Location of Construction: 161 Commercial St	Owner Name: Robertson John O & Sonia B Jts	Owner Address: 161 Commercial Street #101 PORTLAND	Phone:
Business Name: n/a	Contractor Name: Black Bear Sign	Contractor Address: 137 Rt 1 Scarborough	Phone: 2078835543
Lessee/Buyer's Name: n/a	Phone: n/a	Permit Type: Signs - Permanent	Zone: B-3

Past Use: Commercial / Retail Space	Proposed Use: Commercial / Retail Space; erect 3' x 15' Banner & install 3' x 3' x 3/4 mdo sign	Permit Fee:	Cost of Work: \$1,500.00	CEO District: 1
Proposed Project Description: Erect signage- 3'x5' banner on corner & 3' x 3' x 3/4 MDO Sign		FIRE DEPT: <input type="checkbox"/> Approved <input type="checkbox"/> Denied	INSPECTION: Use Group: <i>Signage</i> <i>BOCA 99</i> Signature: <i>[Signature]</i>	
		PEDESTRIAN ACTIVITIES DISTRICT (P.A.D.) Action: <input type="checkbox"/> Approved <input type="checkbox"/> Approved w/Conditions <input type="checkbox"/> Denied Signature: _____ Date: _____

ADDRESS: 161 Commercial St.
 PERMIT APPLICATION FOR: sign
 BUILDING OWNER: John Robertson
 PERMIT APPLICANT: Black Beach Sign
 REVIEWER: John Anderson
 DATE OF DECISION: 2/5/02

HISTORIC PRESERVATION REVIEW

CORNER OF BUILDING

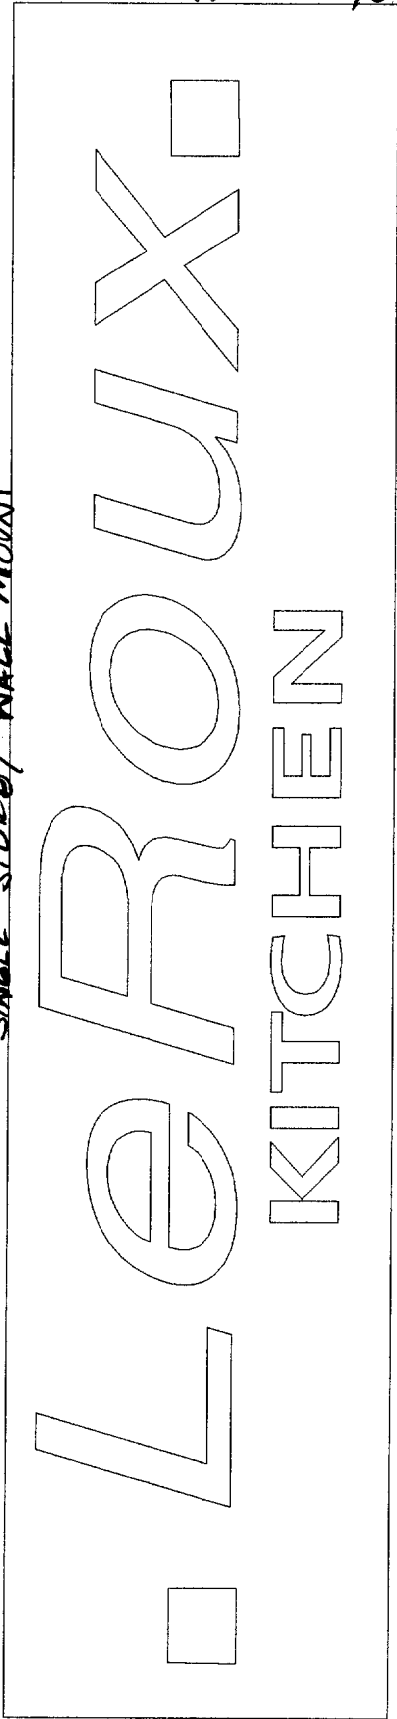
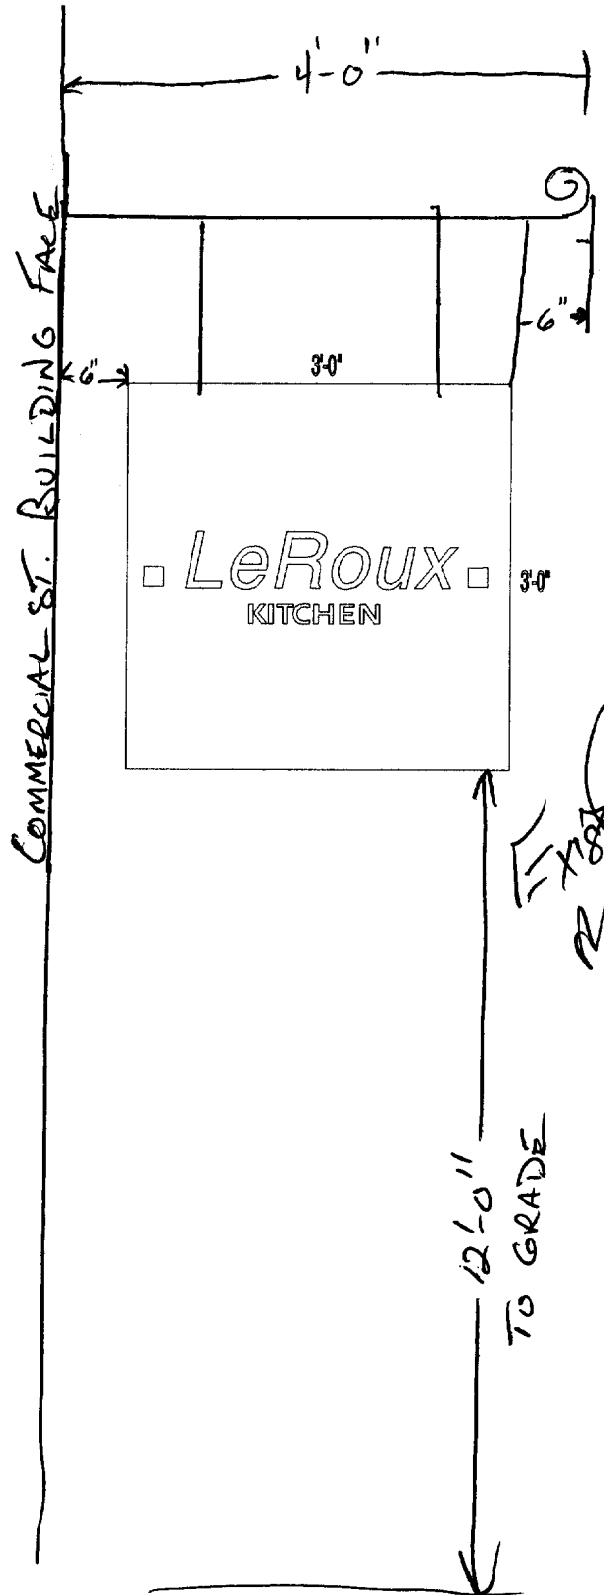
This approval is for the 3' X 3' sign only. The 3' X 15' Banner is NOT approved.

- Denied *for banner* Reason for Denial: sign does not meet H.P. standards
- Approved as submitted *→ for 3x3' sign* excessive sign
- Approved with conditions (see below)
